Subject: FW: 8 cross church street paddock HD14SN 2023/93239

Sent: Friday, December 15, 2023 8:33 PM
To: Tom Hunt <Tom.Hunt@kirklees.gov.uk>
Subject: 8 cross church street paddock HD14SN

SIDE ELEVATION AS PROPOSED (SOUTH)
SCALE 1:100

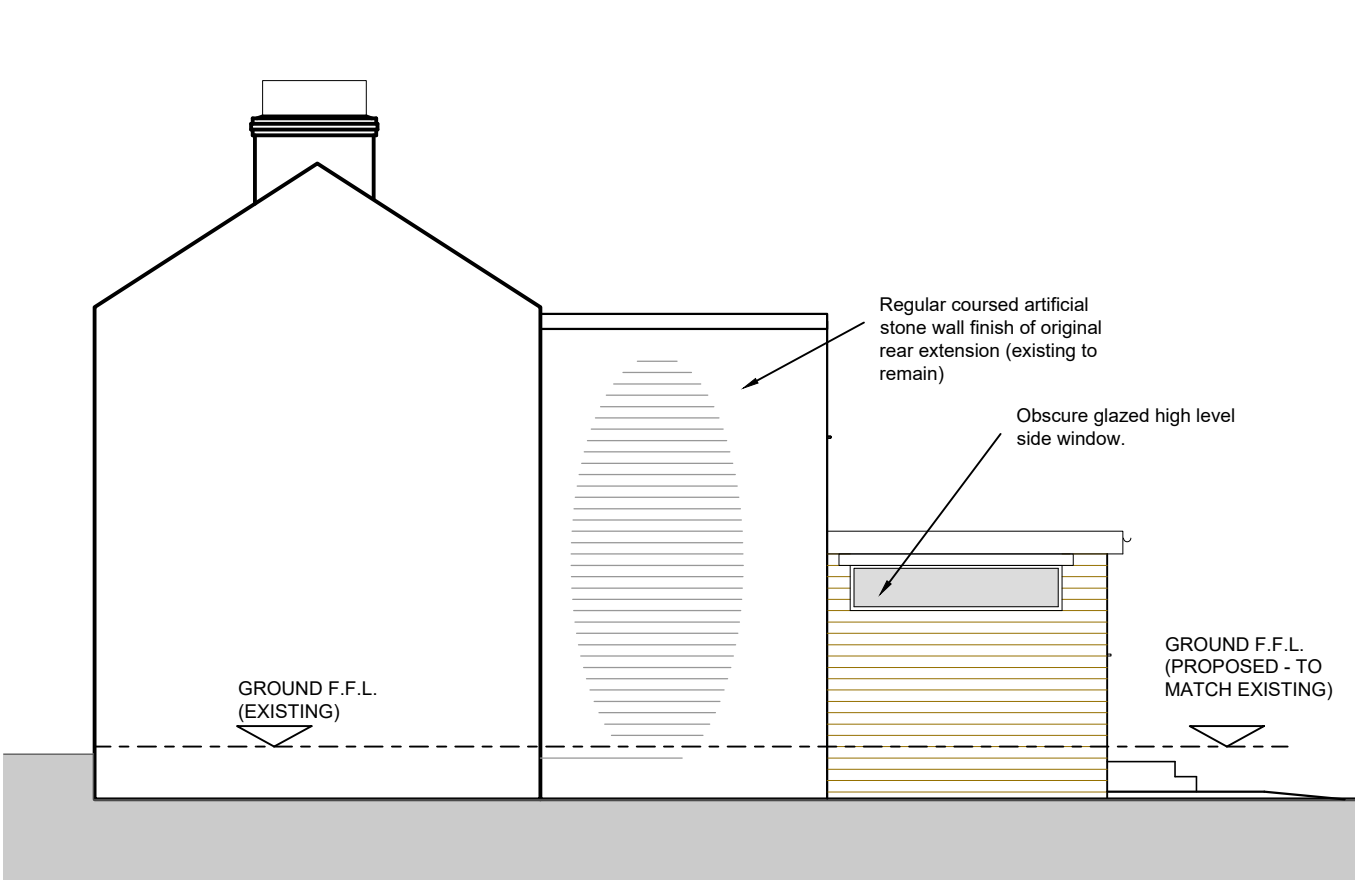
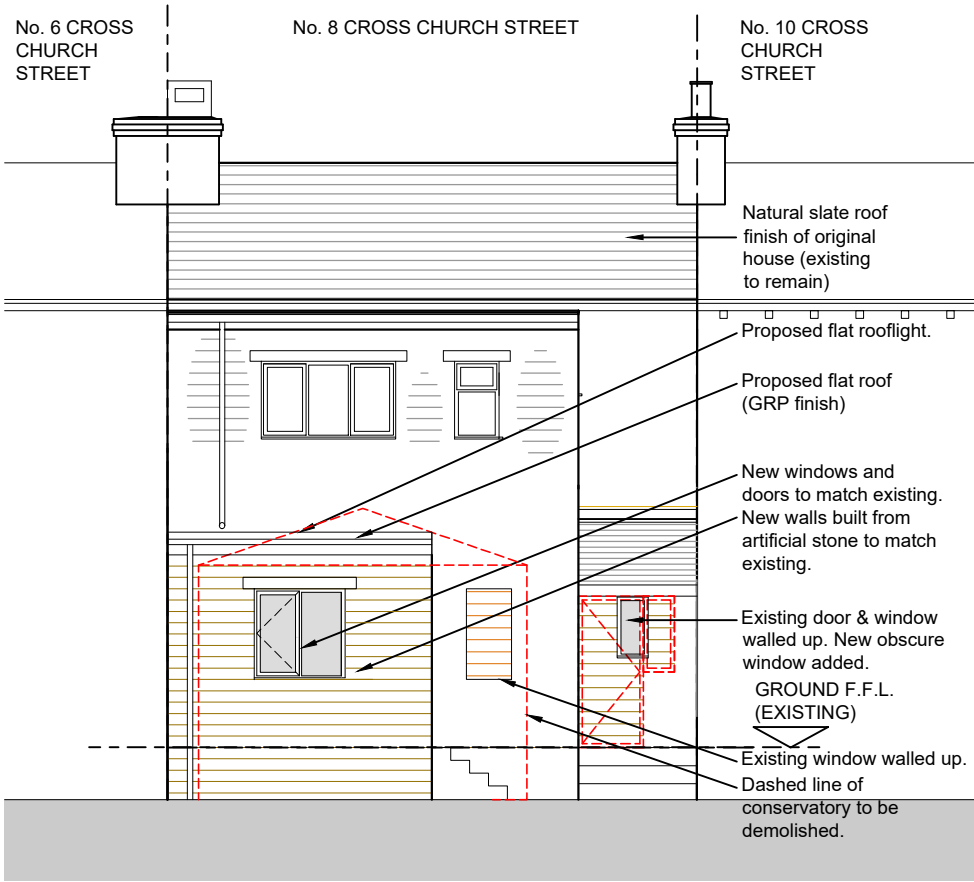
So could you and the relevant committee consider the proposed height of the proposed pitched roof ? I have also been asked the South wall , If it will be reduced by your 1 Meter from Boundary Criteria as the North facing side has and if not why not as they say " whats good for the Goose is Good for the Gander " the South Facing Wall is Overbearing and Claustrophobic and makes seem like a courtyard and also takes away what used to be a limited outlook to Zero outlook

The south facing wall of the First new build which has been refused by Kirklees and the Secretary of state
Intimidated
